SUBJECT: SFD2407-0045
SINGLE FAMILY DWELLING

Here are the results of all Inspections located at **29 ASHBROOK CV:**

**FIRST FLOOR**

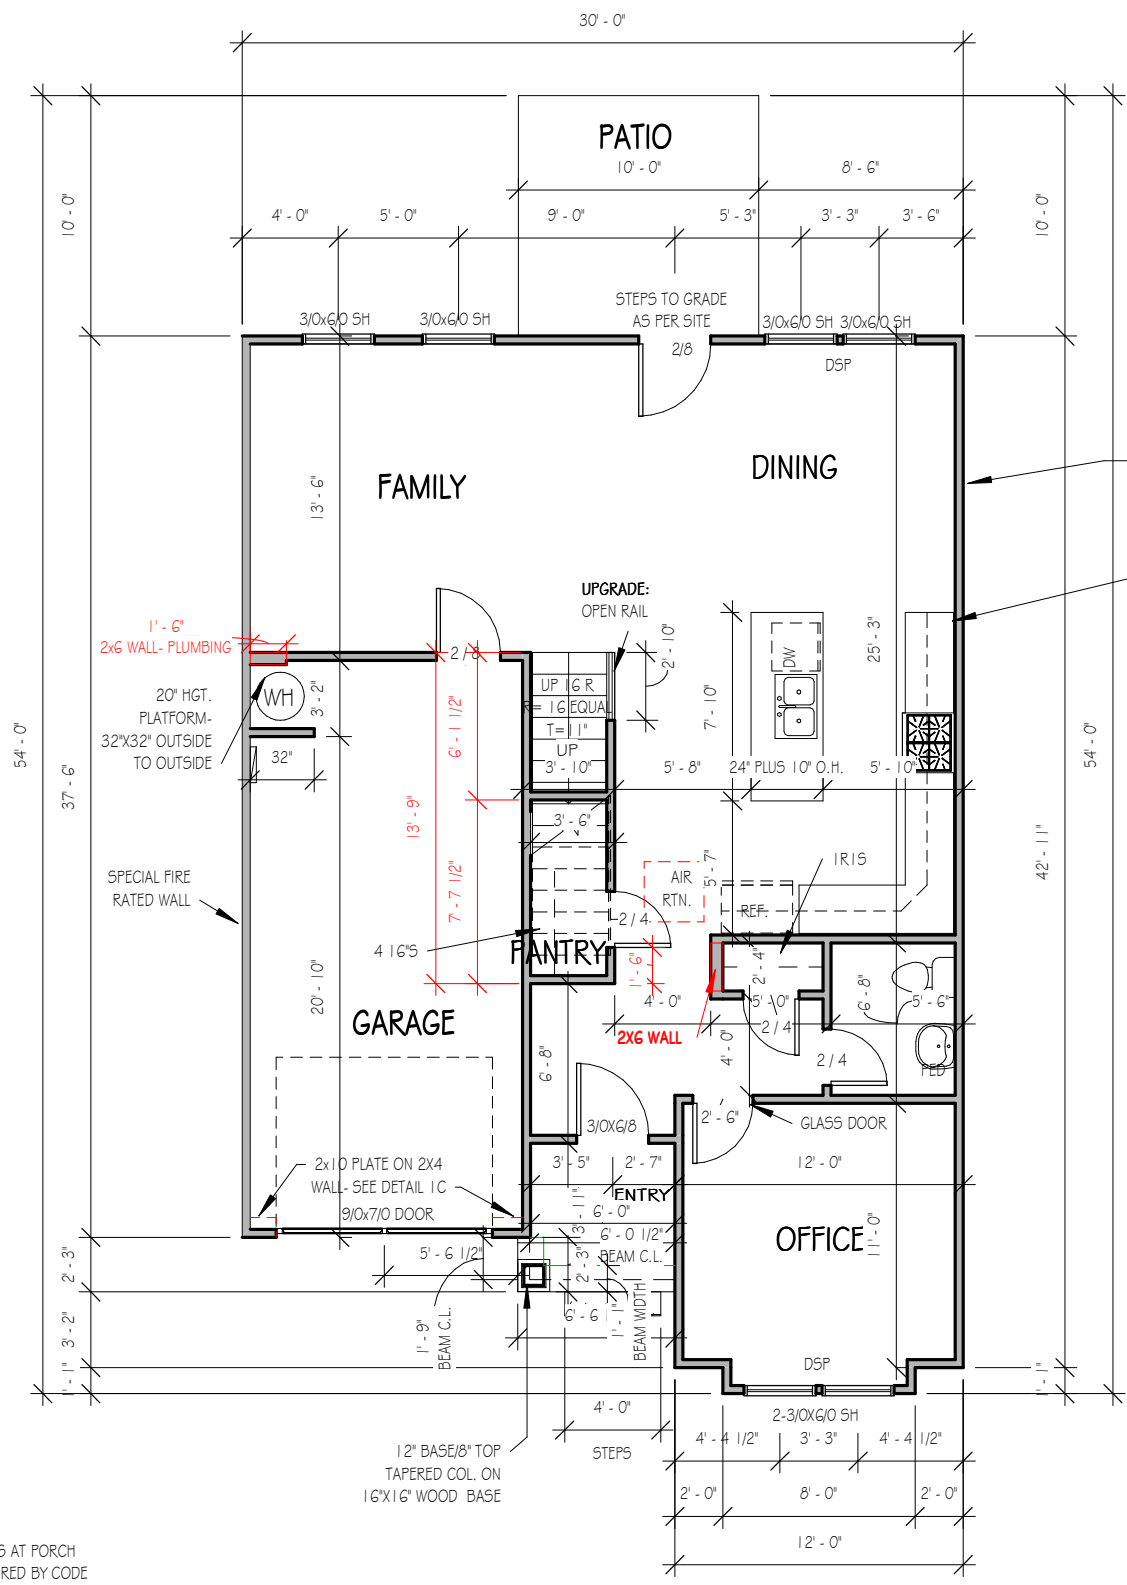
1. Add cripples above top plate at stud column in front right room to transfer load down. 2. Nail stud shoe to studs downstairs powder room. 3. Ok to insulate
